## Apostolic Christian Church Expansion Traffic Memorandum (LSC #184930) October 26, 2018

RE: Apostolic Christian Church Expansion  
El Paso County, CO  
Transportation Memorandum  
LSC #184930

# SITE PLAN

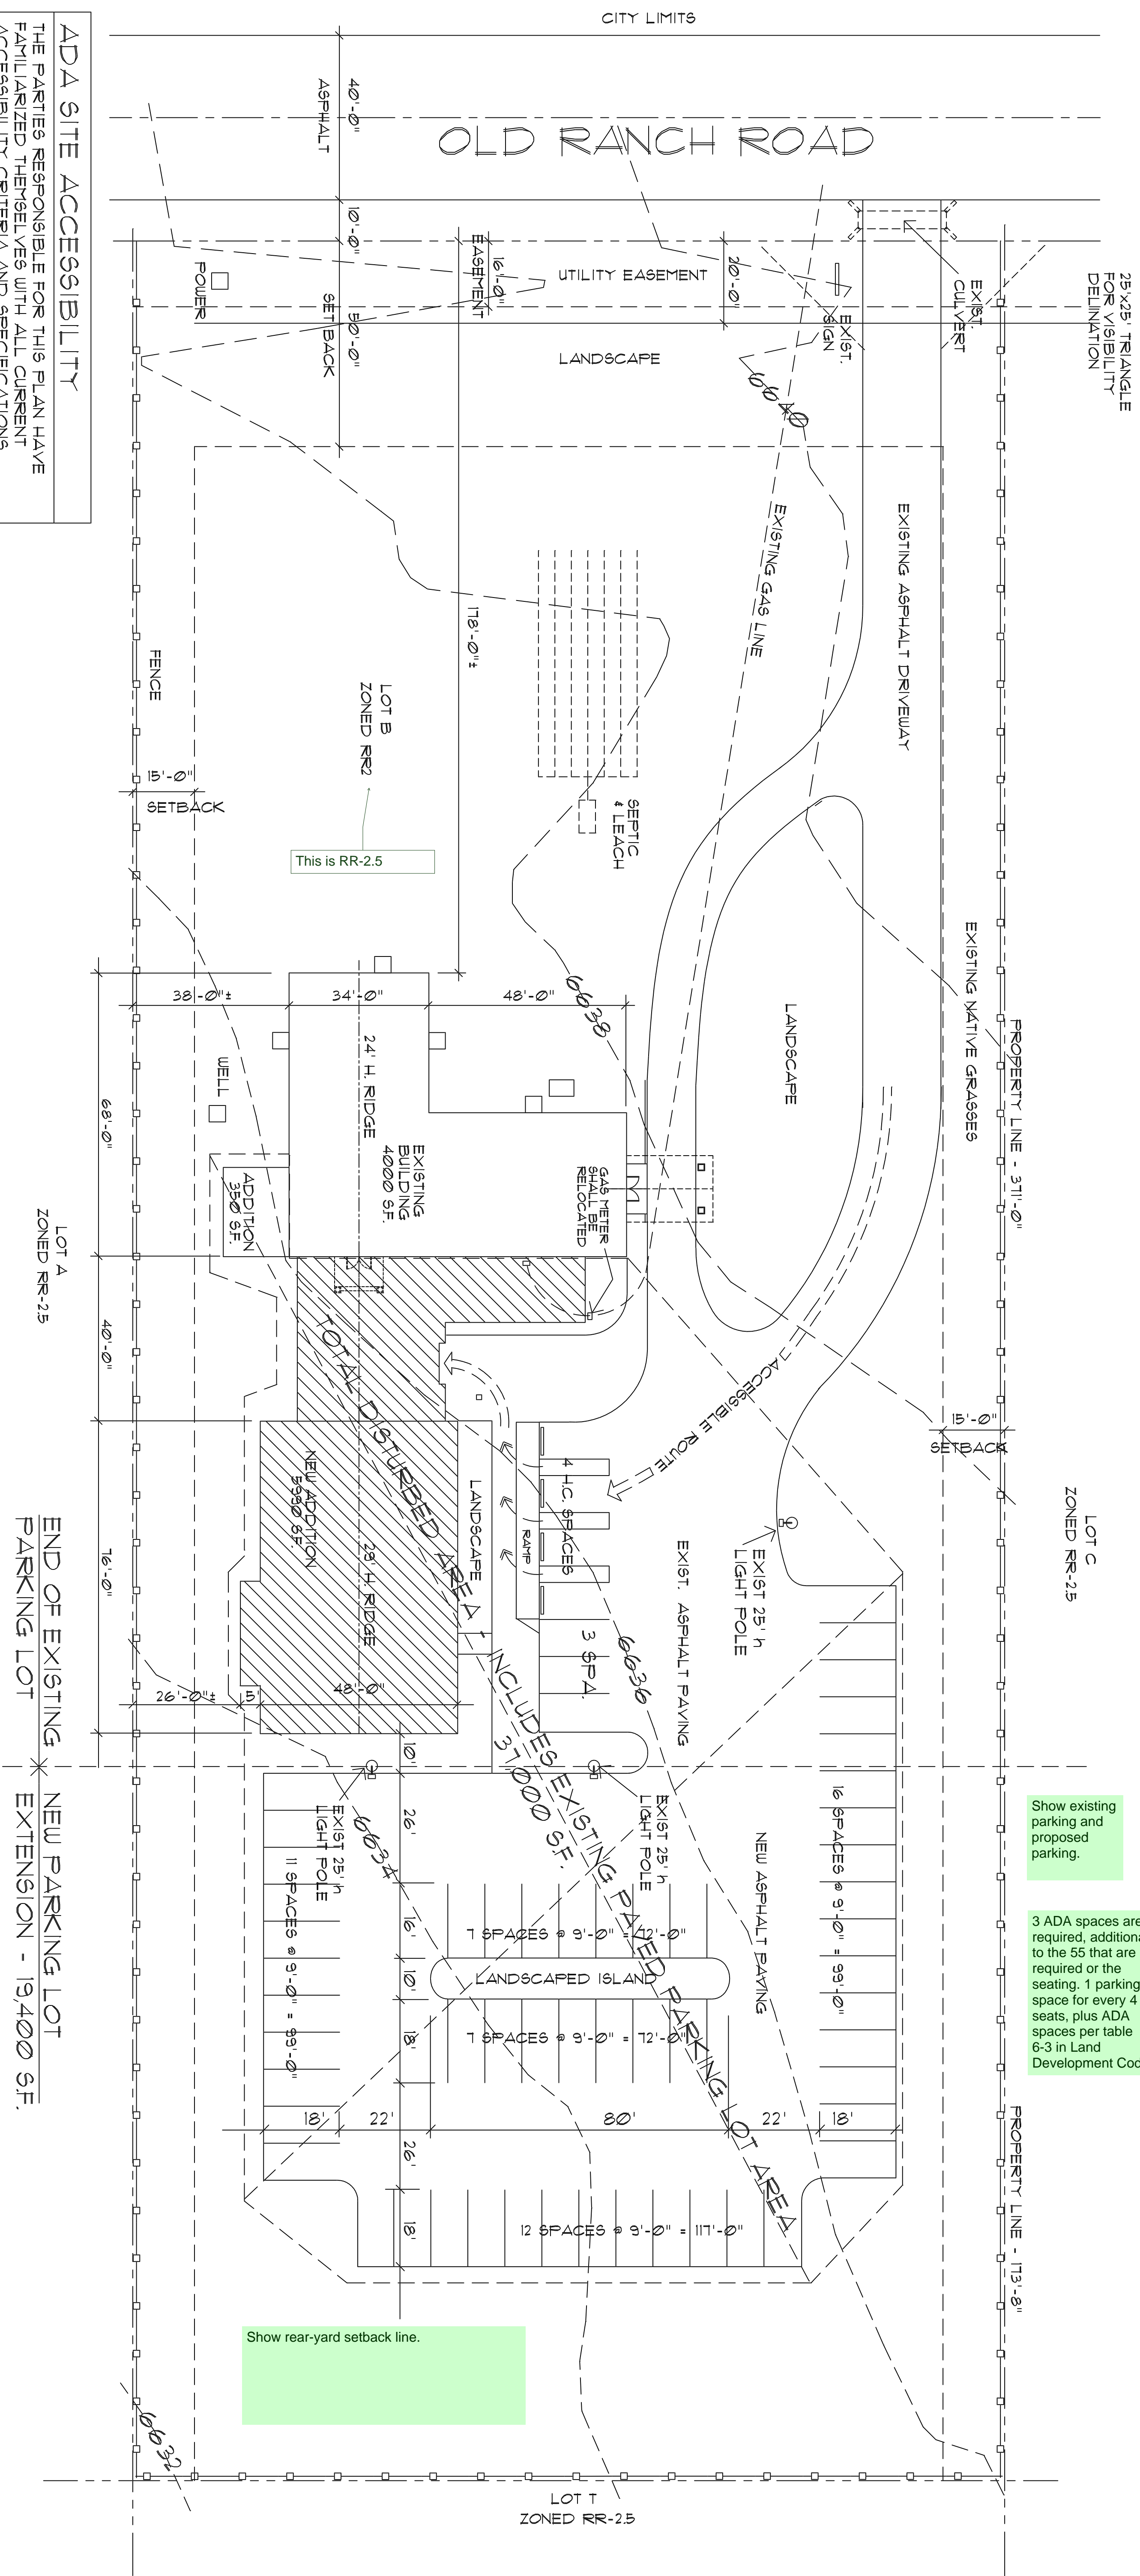
The report provided a conclusion of no "No change to the site access is proposed" without providing analysis of the project related impacts.

Provide the following analysis/narrative:

1. Project related impact to the adjacent road. The Sunday PkHr is more than doubled. What is the PkHr LOS? Is there an increase in delay for through traffic on Old Ranch Road? If not within acceptable standards provide recommendation.
2. Are there potential project-related impact on the adjacent residential neighbors such as speeding or volume concern? If so, provide recommendation.
